CITY OF ALBUQUERQUE

July 20, 2014

**RE: McDonald's - Old Town MRP
2305 Central Avenue NW (Lot 5-B, Block 2, Traction Park Addition)
Erosion and Sediment Control (ESC) Plan (J13E053)
Engineers Stamp Dates 1-27-14 (Sheet C1) & 5-27-14 (Sheet C3 & C4)**

SHEET NO. C-3

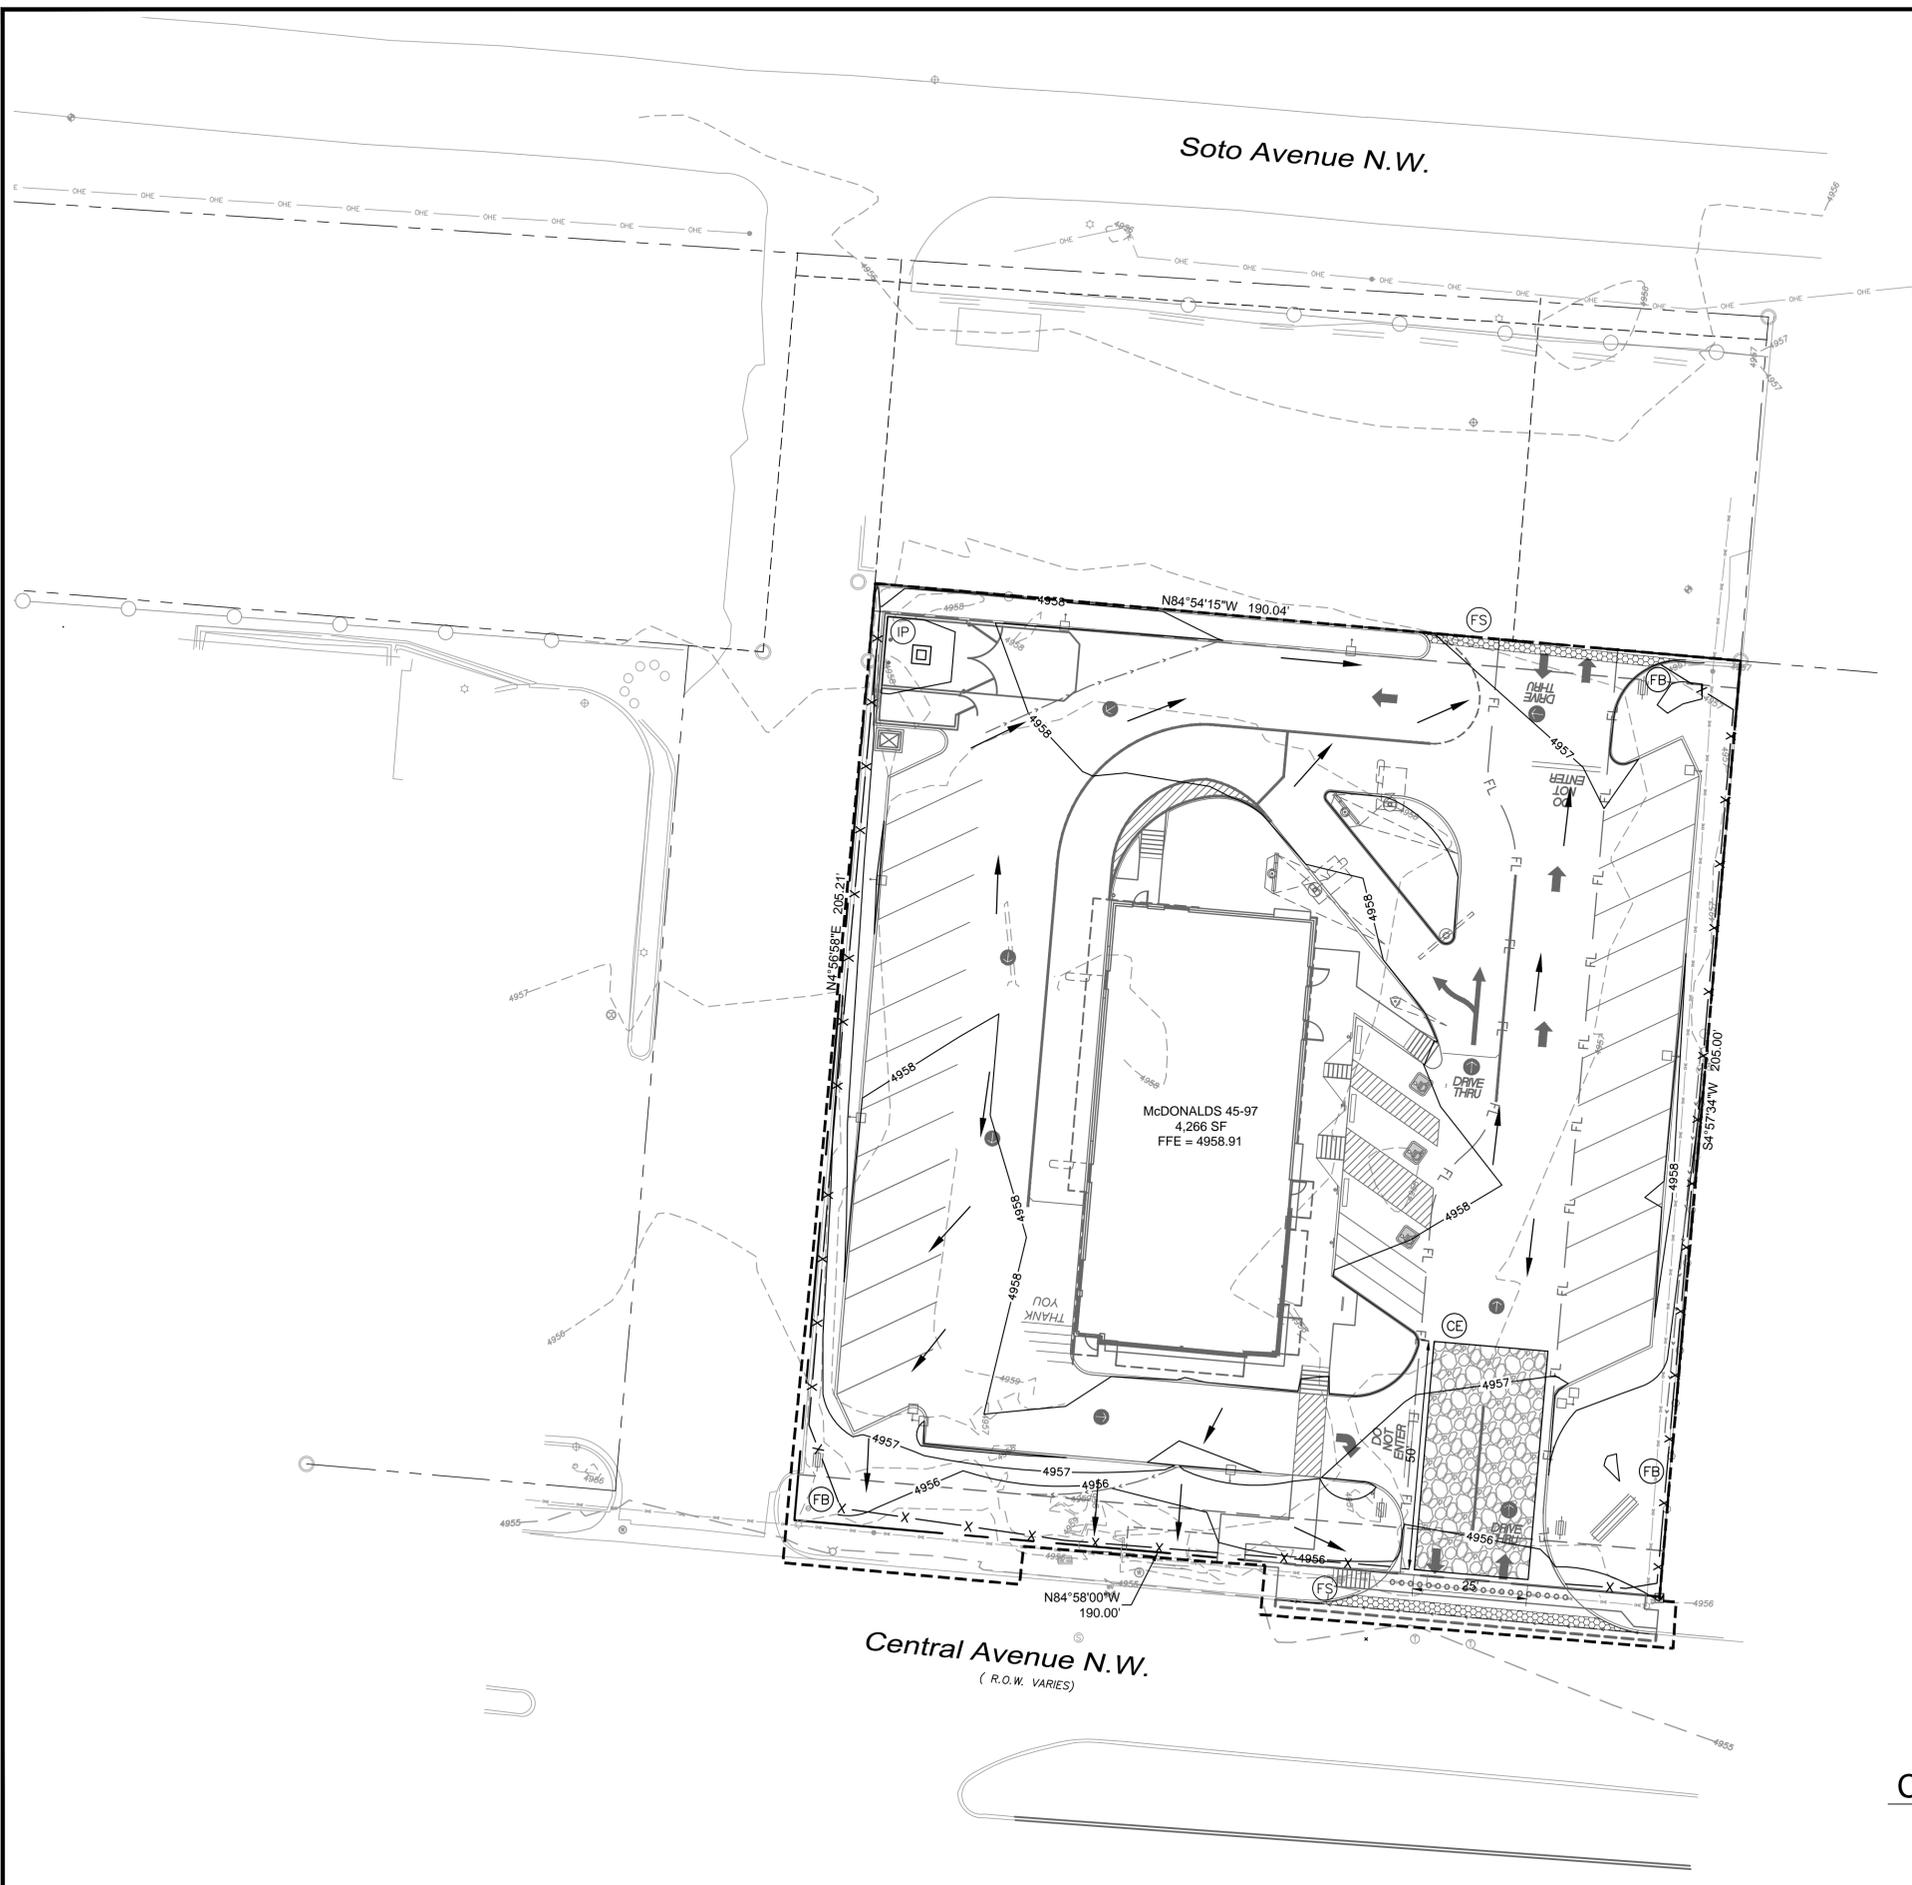
_Sign posting should be visible from Public Street.
